Section 55

Acceptance of Applications Checklist

Fosse Green Energy Section 55 Acceptance of Applications Checklist

Figure 11-1

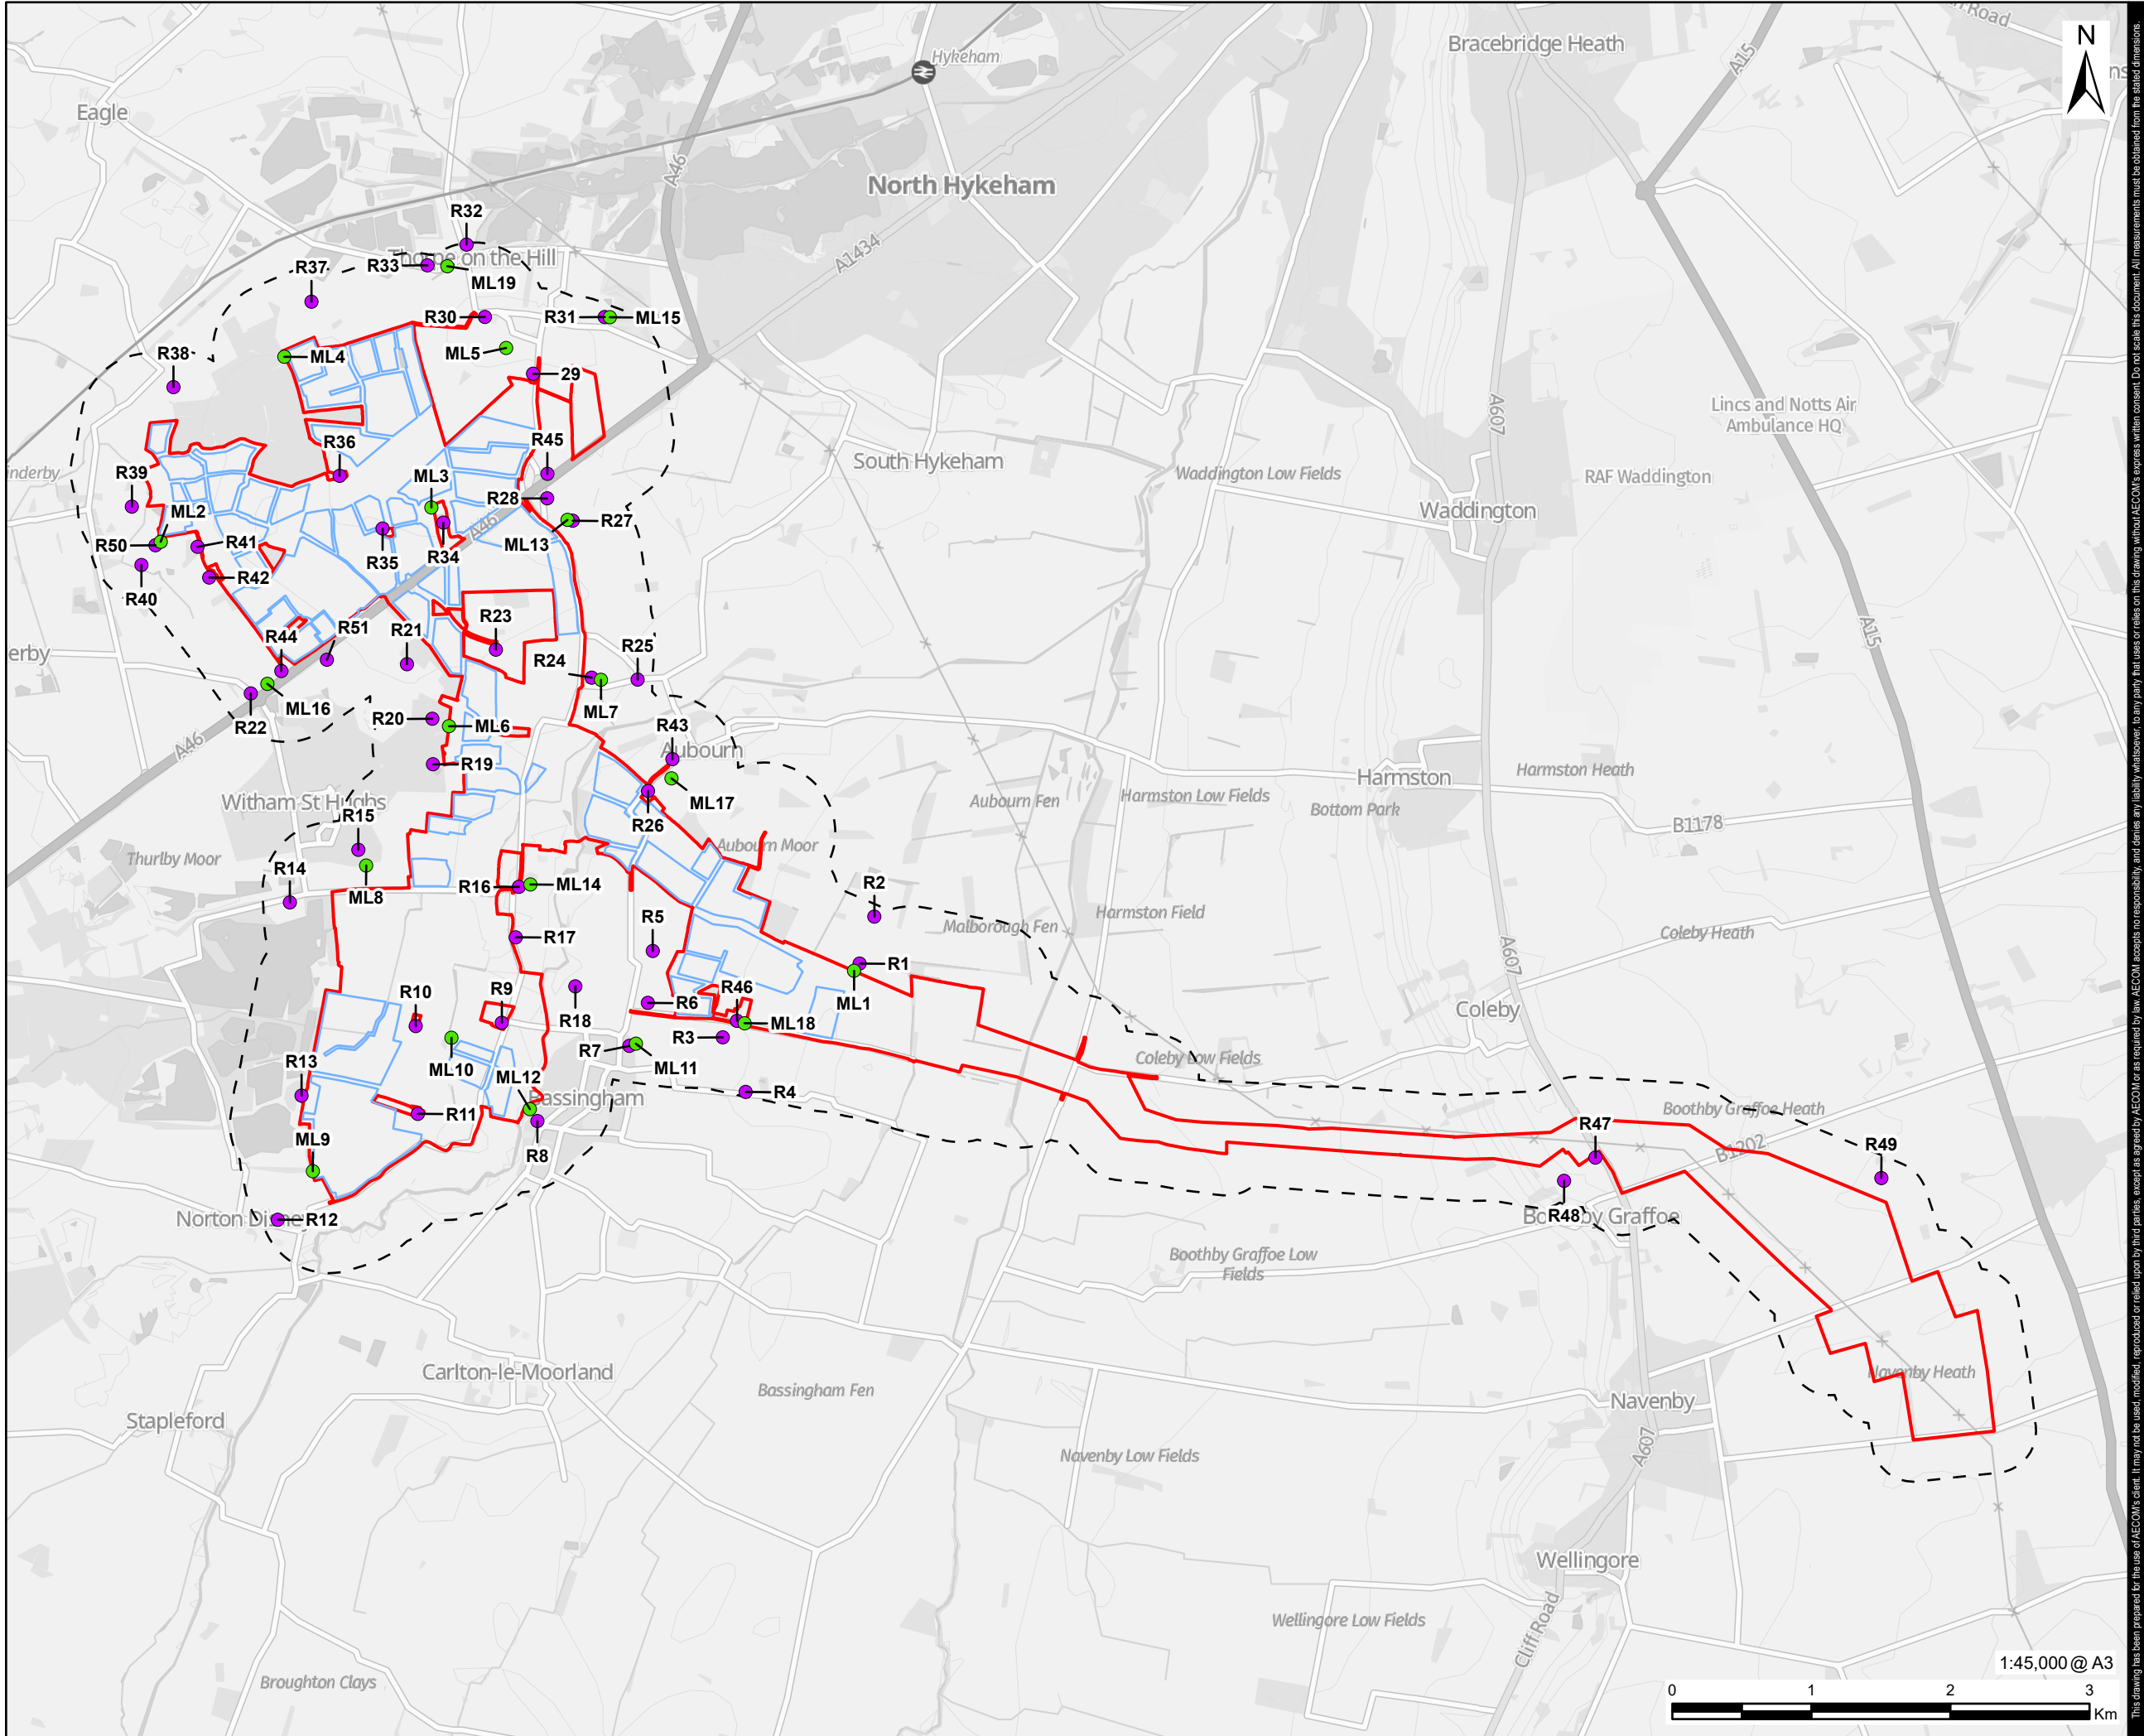
Chapter 11 (Noise and Vibration) and Figures 11-1 to 11-3 seek to identify and show the locations for noise receptors and monitoring and the predicted noise contours for the centralised and distributed Battery Electrical Storage System (BESS). However, the information provided respectively in Tables 11-5 and 11-6 in Chapter 11 provide very brief descriptors for the receptor and monitoring locations, while Figures 11-1 to 11-3 have been drawn on Ordnance Survey Map bases providing very limited information concerning road numbers and/or street names, collectively making it extremely difficult to identify the precise locations for the noise receptor and/or monitoring locations. Readily relating the locations for the receptor and monitoring sites with the predictions for the noise contours for the centralised and distributed BESS is extremely difficult because the receptor and monitoring locations are not shown on Figures 11-2 and 11-3 and those figures have been drawn to a different scale to the scale of Figure 11-1.
